Subject: FW: 10053: Toddington Lane Littlehampton, Arun District, BN17 7PN APP/C3810/W/18/3197149 (LU/162/17/PL) Condition 14

I have reviewed the latest plan provided by GTA and am satisfied with what is being proposed, I would therefore advise this satisfies Condition 14.

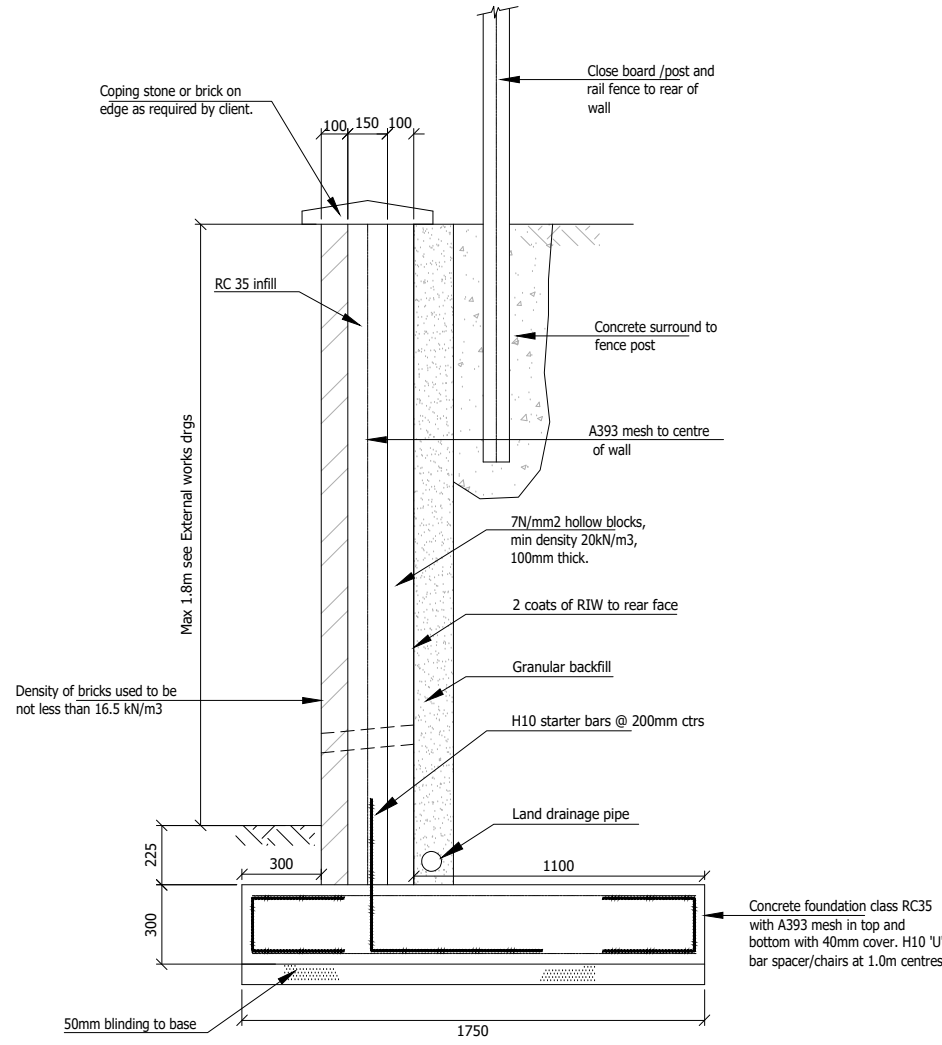
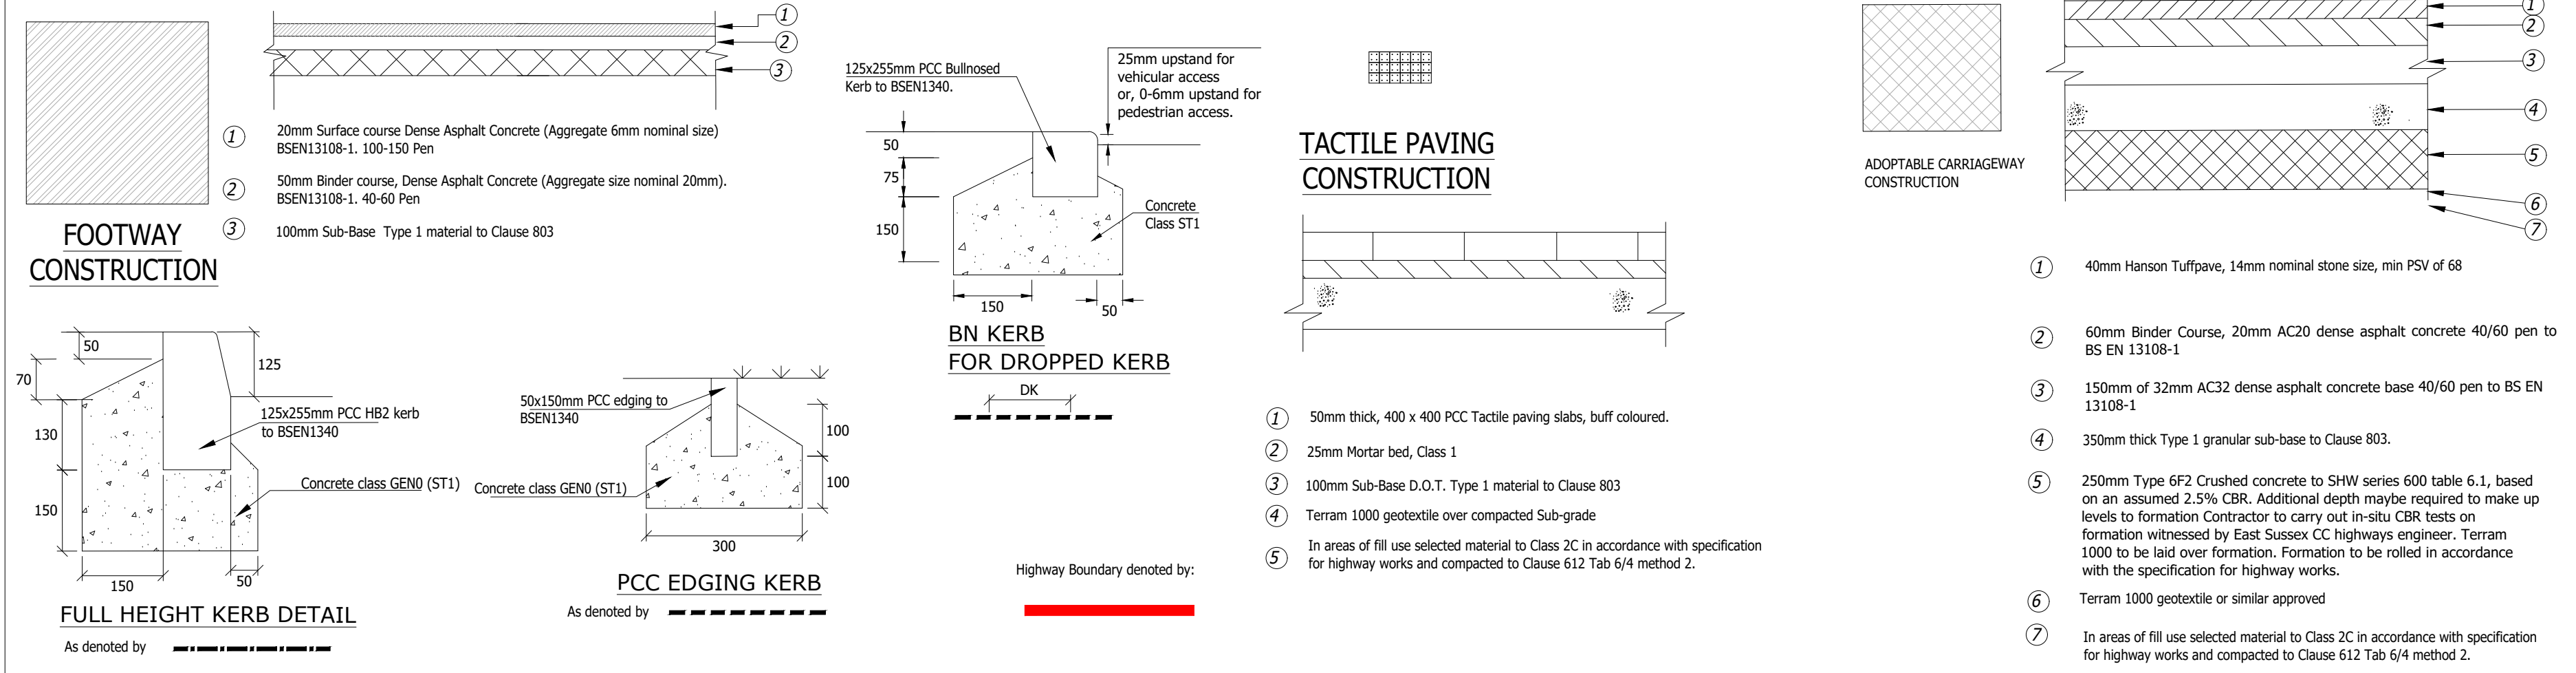
In principle I think we could accept the 1 metre. However just one point I would like to confirm, the 66 metre splay to the west can you confirm in a bit more detail it is all contained within highway land as it present it is not stated.

I am contacting you in regards to the development at Toddington Lane (LU/162/17/PL) and condition 14. In your comments on 15th October 2019 you asked for A visibility splay of 2.0m * 66m in both directions at the western end of the proposed footway. This was to ensure any pedestrians crossing in this location have sufficient visibility to see any oncoming cars. The 66m visibility splay is achievable looking west but not looking east.

I note that section 4 of WSCC design guide states that lightly trafficked residential roads have 85thile speeds below 37mph, can have MfS1 standards applied. As this is the case for Toddington Lane, the 66m visibility splay is likely in excess of the stopping sight distance for westbound vehicles will need to see pedestrians. Using MfS1 standards and the recorded 28mph 85thile speed there is a stopping sight distance requirement of 39m.

I also note that the visibility splay asked for is from 2.0m, the proposed footway is 2m in width and it is unlikely a pedestrian would be stood on the back edge of the footway, would a visibility splay from 1.0m be acceptable as this is likely to be more reflective of a pedestrians position on the footway.

With the above in mind I would suggest a 1.0m * 39m visibility splay should be acceptable and allow for the crossing point to function safely. Please see update site layout with the visibility splays, I have shown 66m looking westwards as this is achievable and 39m is achievable looking east. Please note I have shown the 39m visibility splay to 600mm off of the kerb to represent the likely position of a car.

In order to ensure that the visibility splay looking west is entirely within highways land we can only guarantee a 59m visibility splay. In regards to this I would refer to my email to Tim from 19th November:

"I note that section 4 of WSCC design guide states that lightly trafficked residential roads have 85thile speeds below 37mph, can have MfS1 standards applied. As this is the case for Toddington Lane, the 66m visibility splay is likely in excess of the stopping sight distance for westbound vehicles will need to see pedestrians. Using MfS1 standards and the recorded 28mph 85thile speed there is a stopping sight distance requirement of 39m."

As such I would contend the 59m visibility splay entirely within the highway boundary should be acceptable.
